# JUDGE ORR PLANT

## Traffic Analysis

Add "PCD File No. VA-19-002" in the cover sheet.

# CONCEPT SITE PLAN

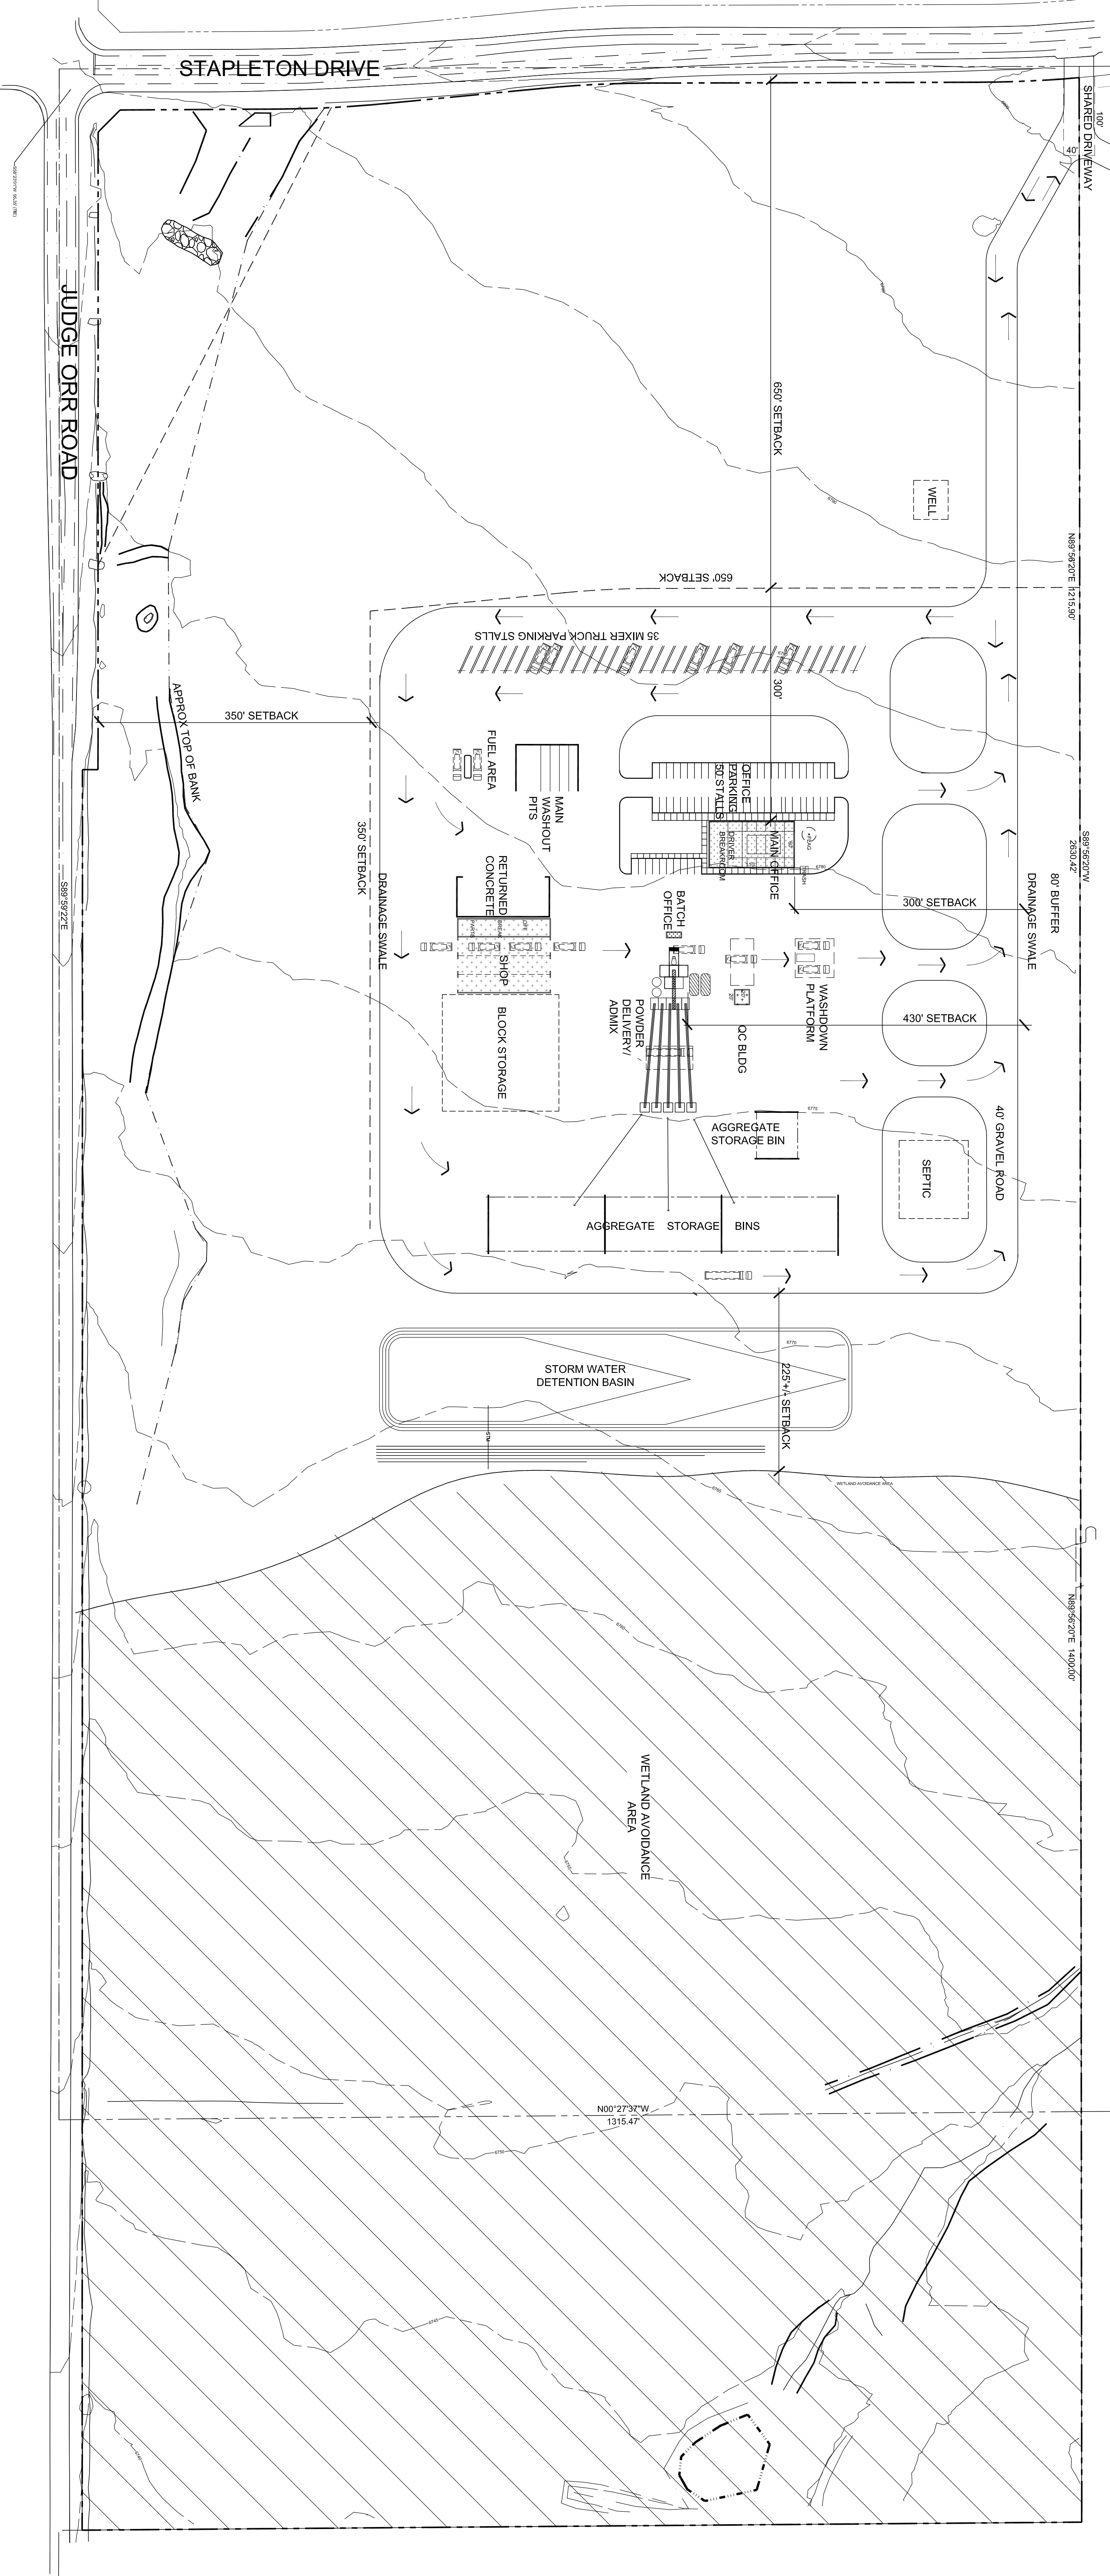
Additionally, the site plan submitted shows 62 office parking stalls and 35 mixer truck parking which is significantly larger than the 20 employees and 15 mixer trucks identified in the report and operations plan.

As Constructed		Stapleton Drive Extension ROW Plan – Stapleton Dr.		Project No./Code	
No Revisions:				229036	
Revised:	Designer:	KMD	Structure Numbers		
	Detailer:	KWD			
Void:	SheetSubset:	Subset Sheets: 13 of 16		Sheet Number R-13

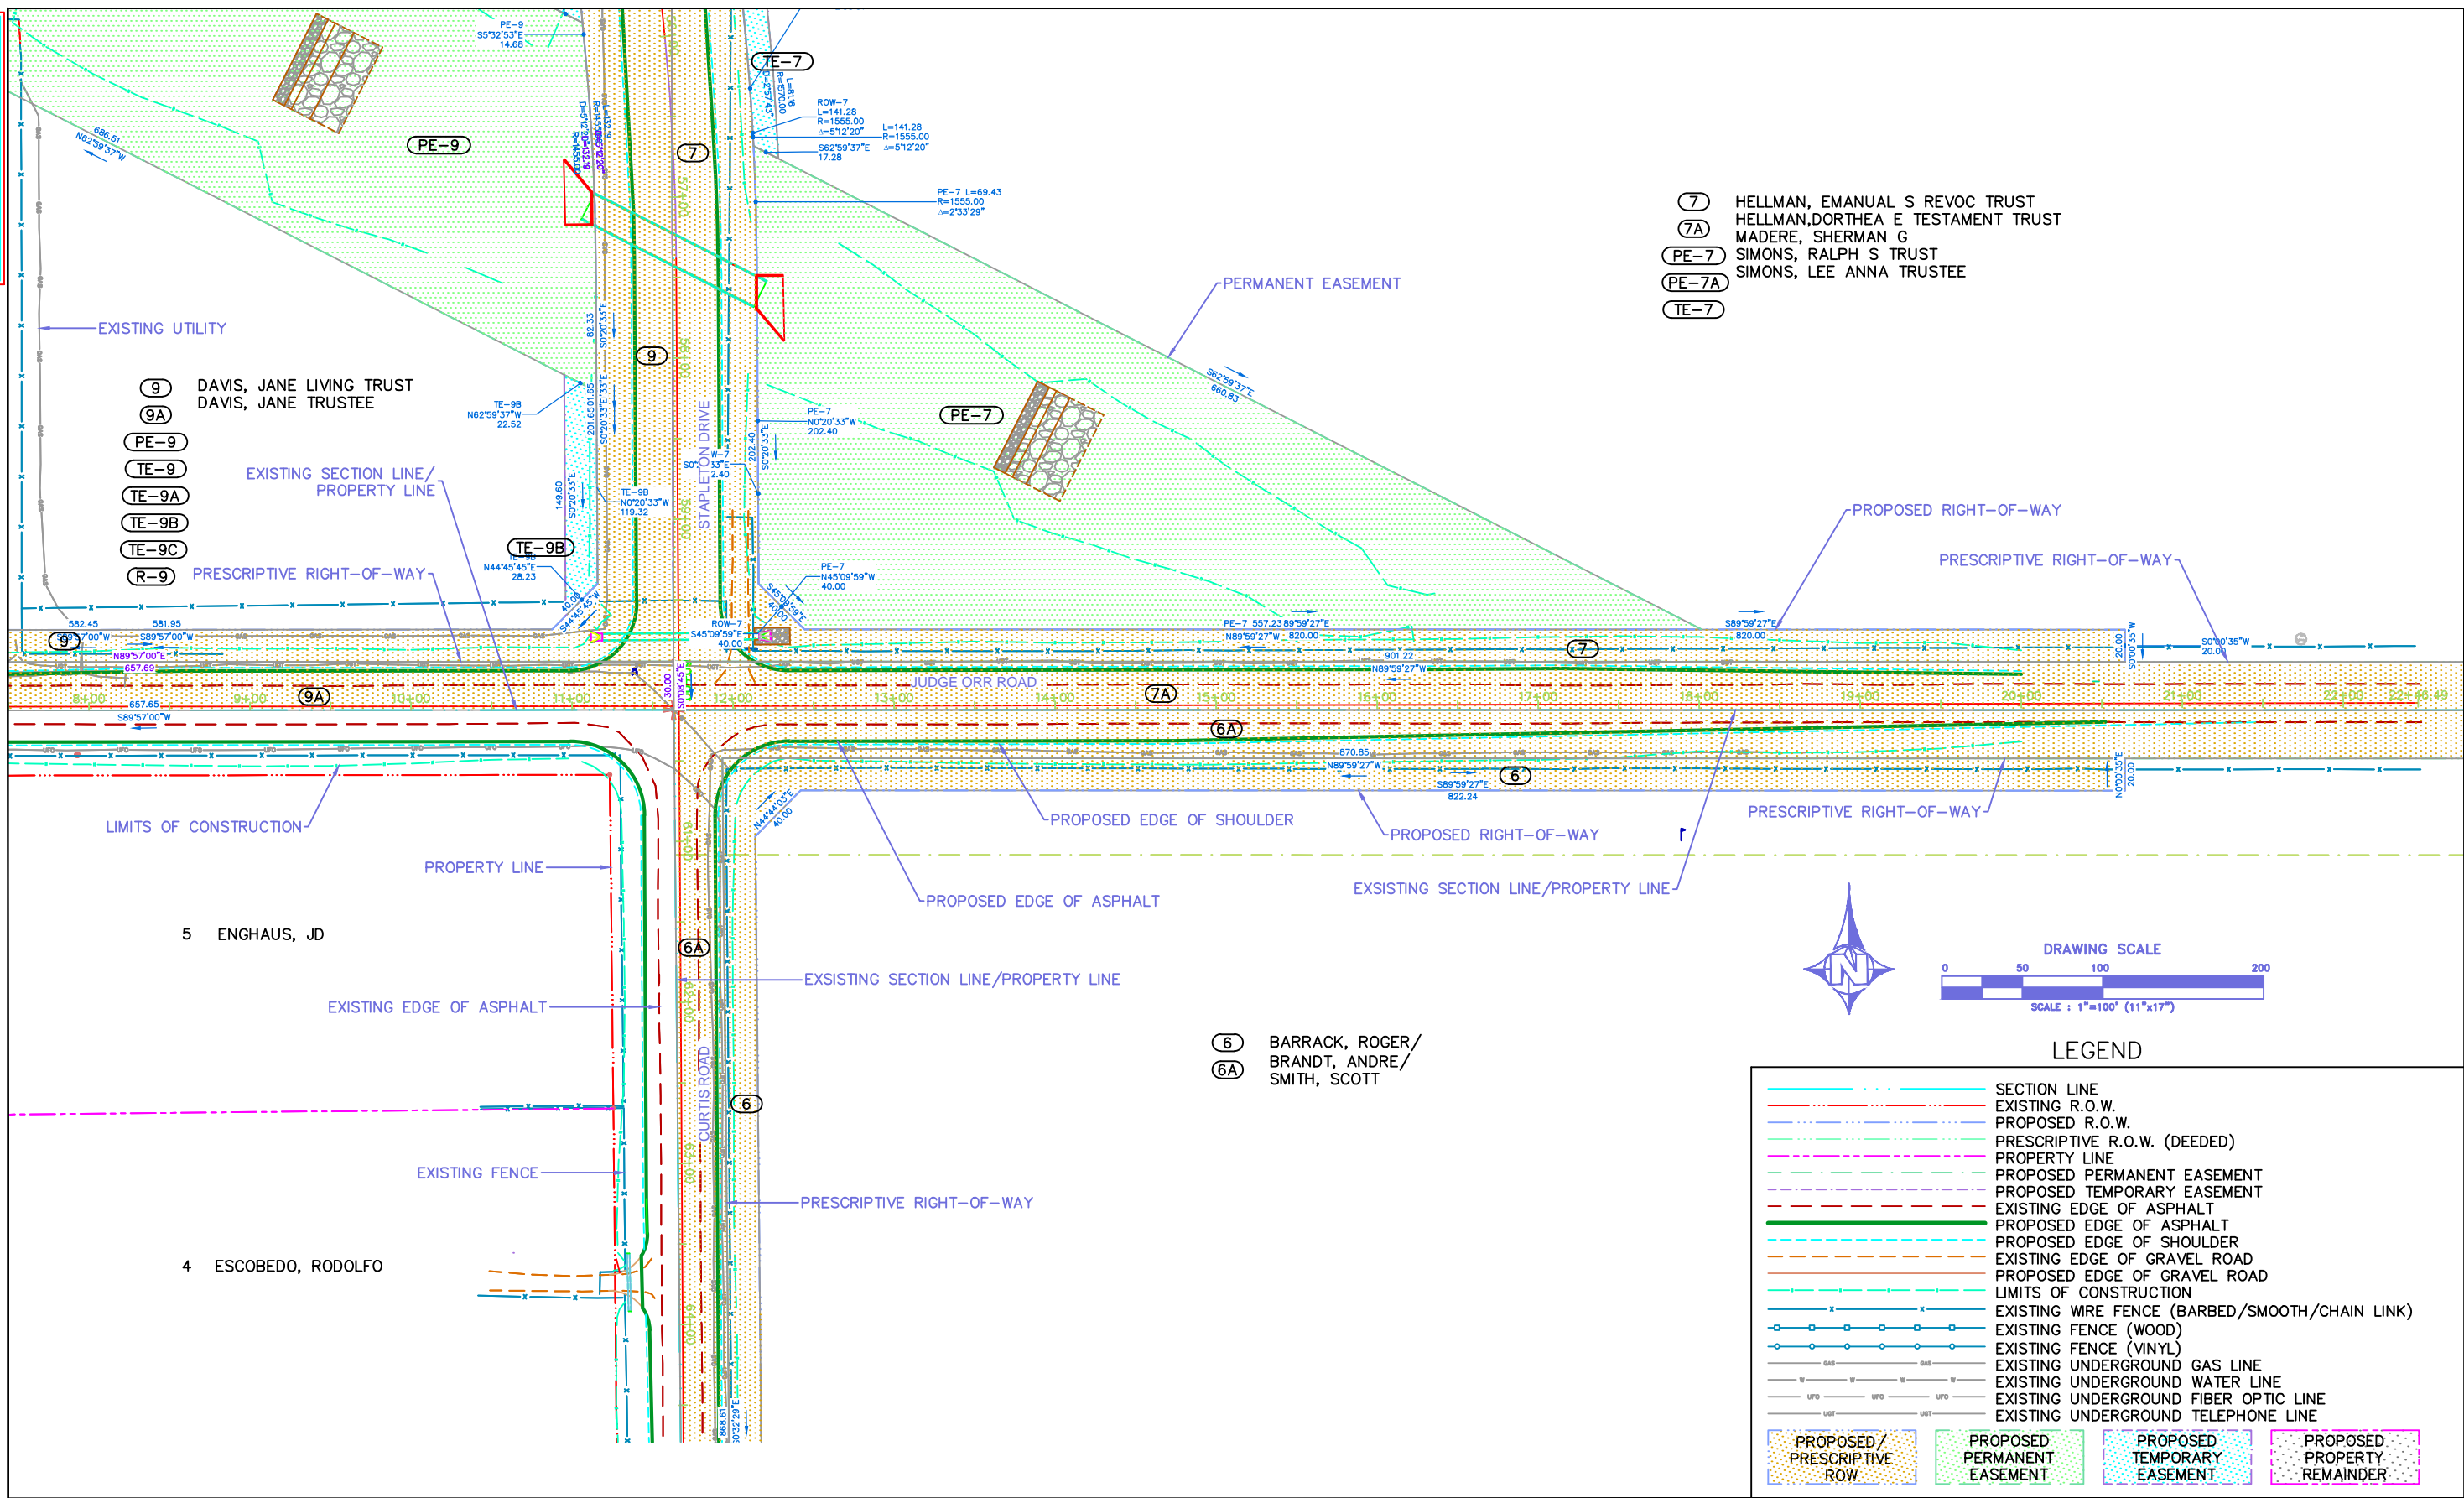
FYI: Based on the MTCP Roadway Improvement Projects, Staple Drive is anticipated to be an Urban 4In Principal Arterial which includes a raised median. There is a potential that the access may restricted in the long term to a RI/RO.

Per ECM Table 2-6 and ECM Section 2.2.4.B.2 no direct parcel access is allowed. Therefore submit a deviation request.
